Rezoning Transportation Analysis

Petition Number: #2022-078

Revision Log:

Date	Description
11-02-22	First Review (TM)
01-25-23	Second Review (TM)

SHEET NUMBER **RZ-02**

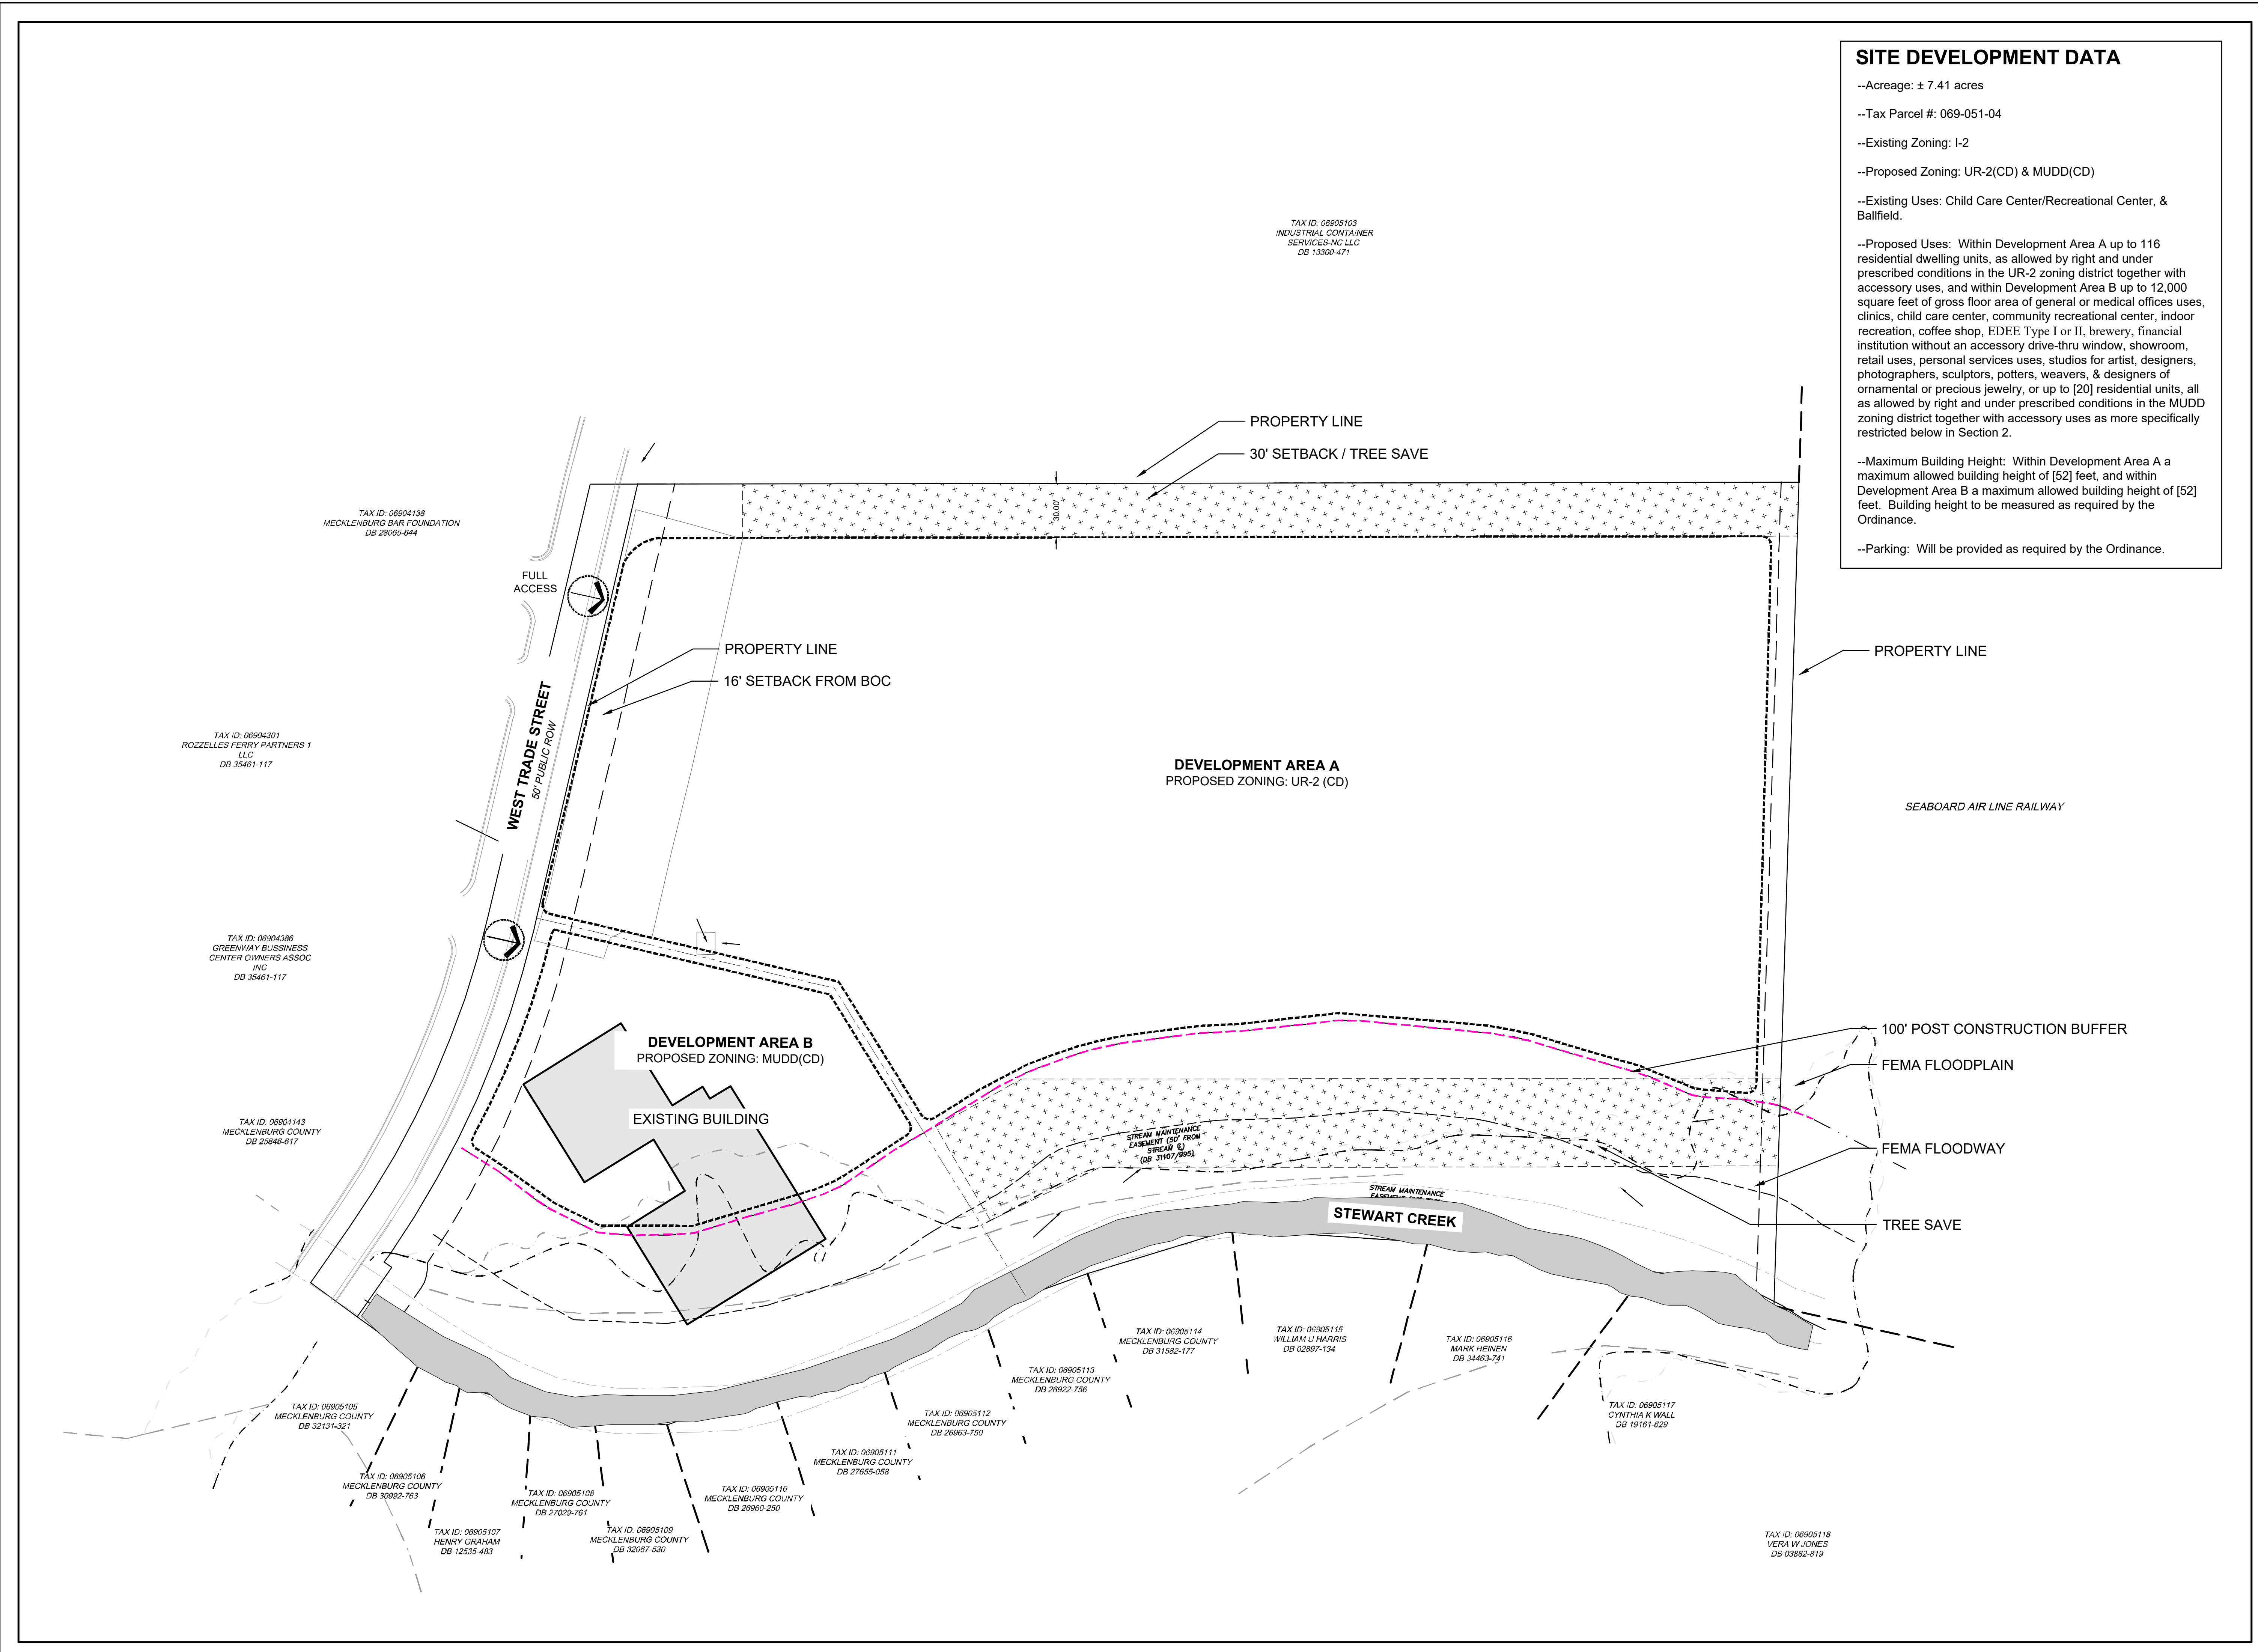
1. ~~**Curblines:** The proposed zoning district has a setback measured from back of the existing or proposed future curblines.~~
 - a. ~~**West Trade Street:** The future location of curb and gutter is measured at 17.5 feet from the centerline of the roadway to the BOC.~~

~~Label and dimension the curb and gutter from the centerline for each road on the site plan.~~

4. ~~Revise site plan to commit to construct an 8-foot planting strip and 8-foot sidewalk along the site frontage per Chapter 19. The site plan shall label and dimension both items from the back of future curb and gutter and road centerline.~~

3. ~~Revise site plan and conditional note(s) to commit to constructing the proposed internal private roadways to private road standard typical section standard per CLDSM 11.13. Site plan shall dimension from the centerline of the roadway and callout roadway typical per CLDSM. Add a conditional note committing to constructing all private streets to the standard of CLDSM 11.13.~~
